DRB CASE ACTION LOG - BLUE SHEET

Project #: 1009597

Project Name: Juan Armijo Addition

**CITY OF ALBUQUERQUE  
PLANNING DEPARTMENT  
February 27, 2013  
DRB Comments**

PLAT OF
LOTS 10-A, 11-A AND 12-A
BLOCK B
JUAN ARMIJO ADDITION

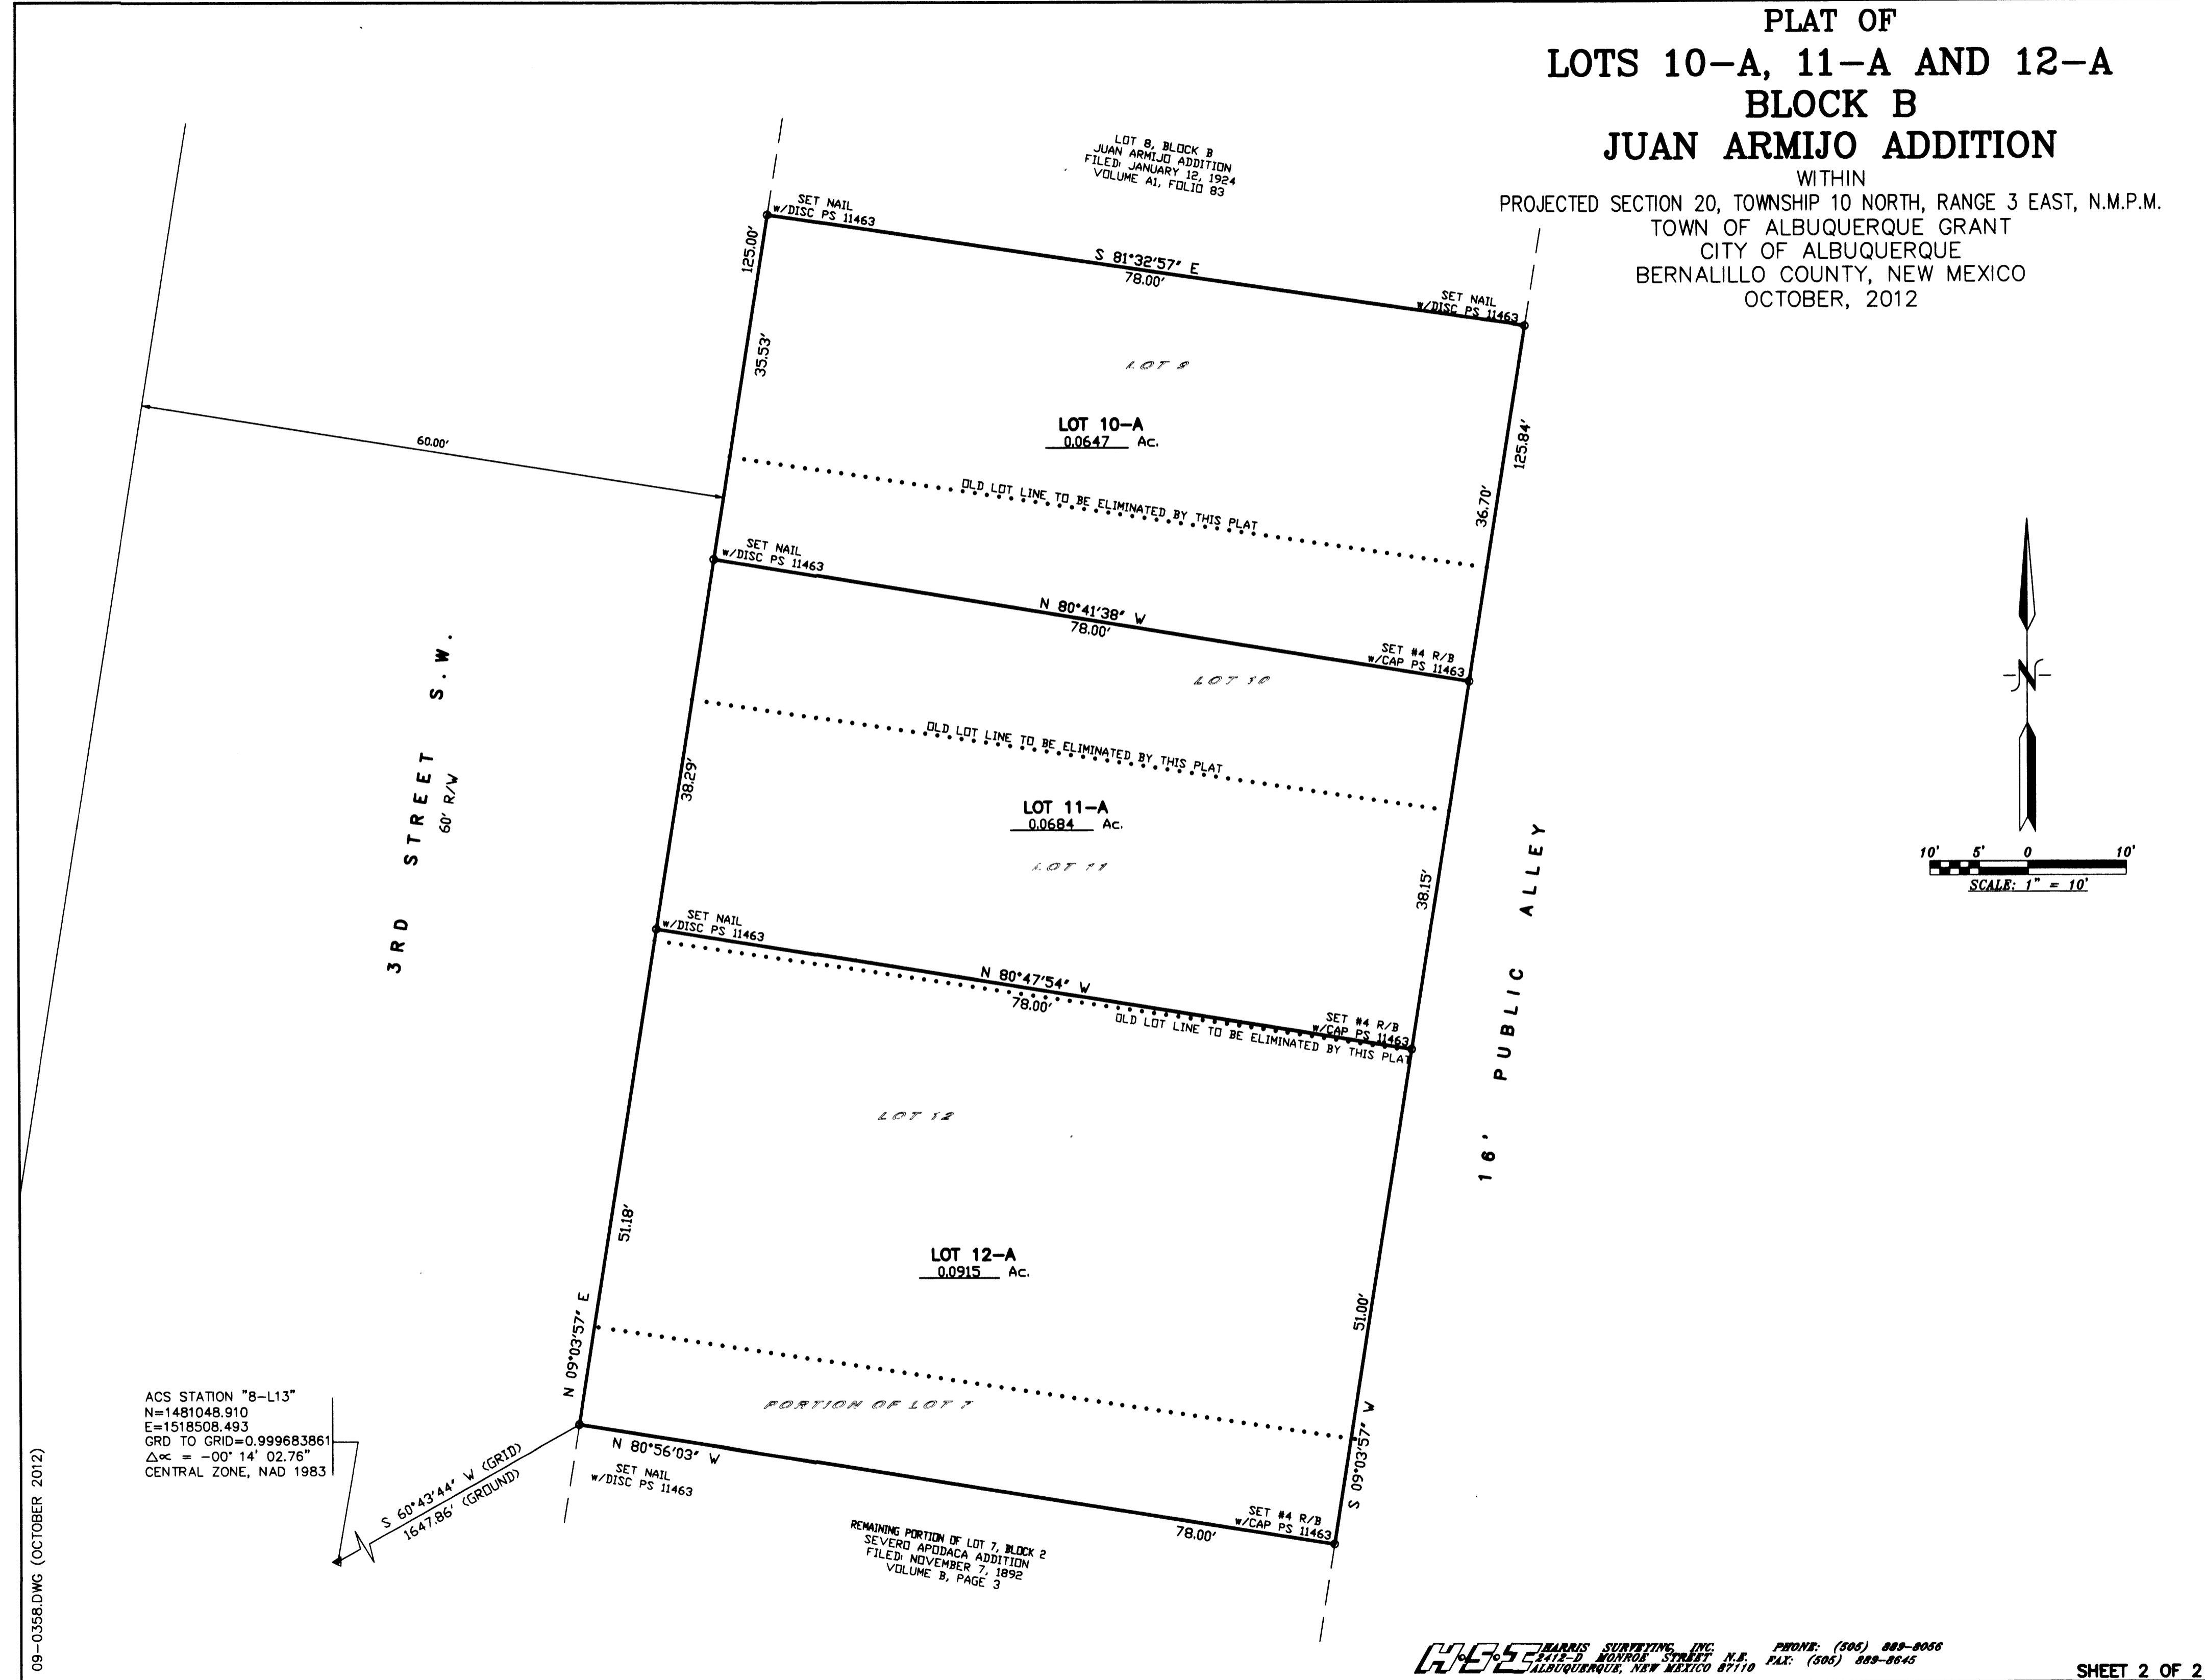
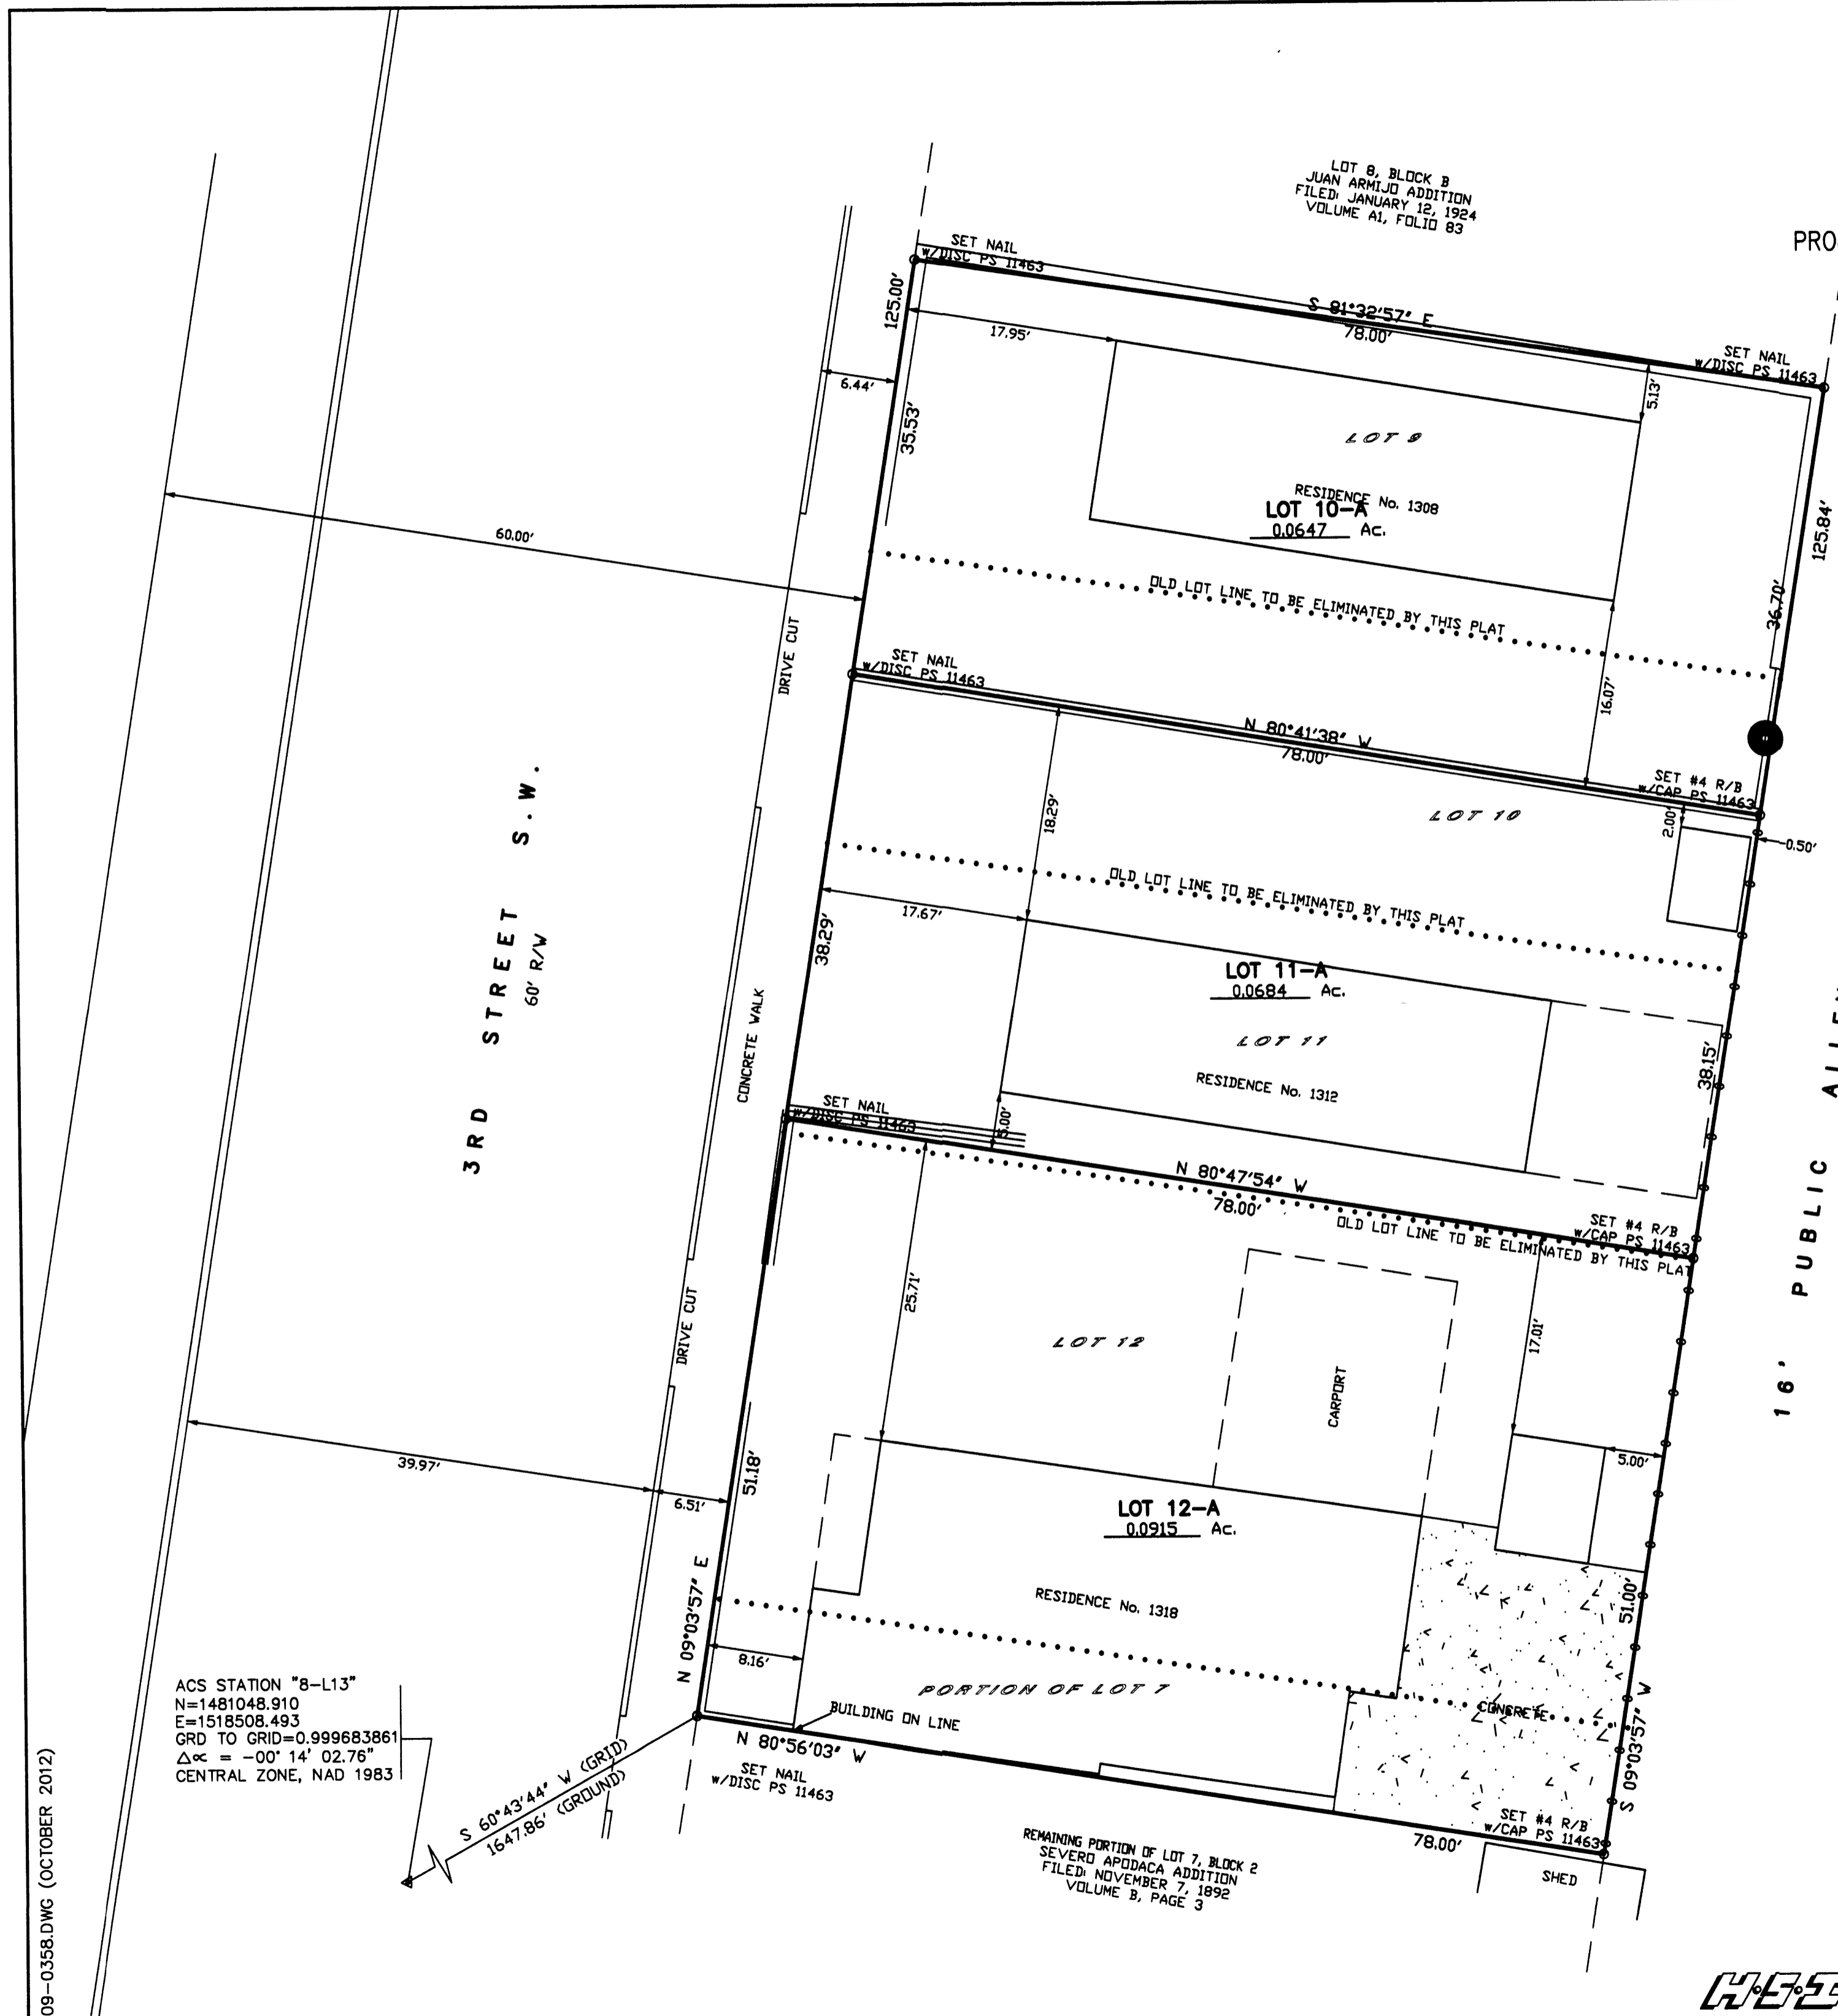
PLANNING (Last to sign): address comment (revised exhibit  
with rear setback dimensioned for lot 11-A)  
utility rig not used, "portions of" Lot 7

Zoning for the site is SU-2/ RG (not A-1 or R-1).

The drawing showing existing improvements appears different than the aerial photo, particularly at the rear of proposed Lot 11-A (there may be an encroachment into the alley).

The creation of "portions of" Lot 7 from the Severo Apodaca Addition must be documented for the file and referenced on the plat.
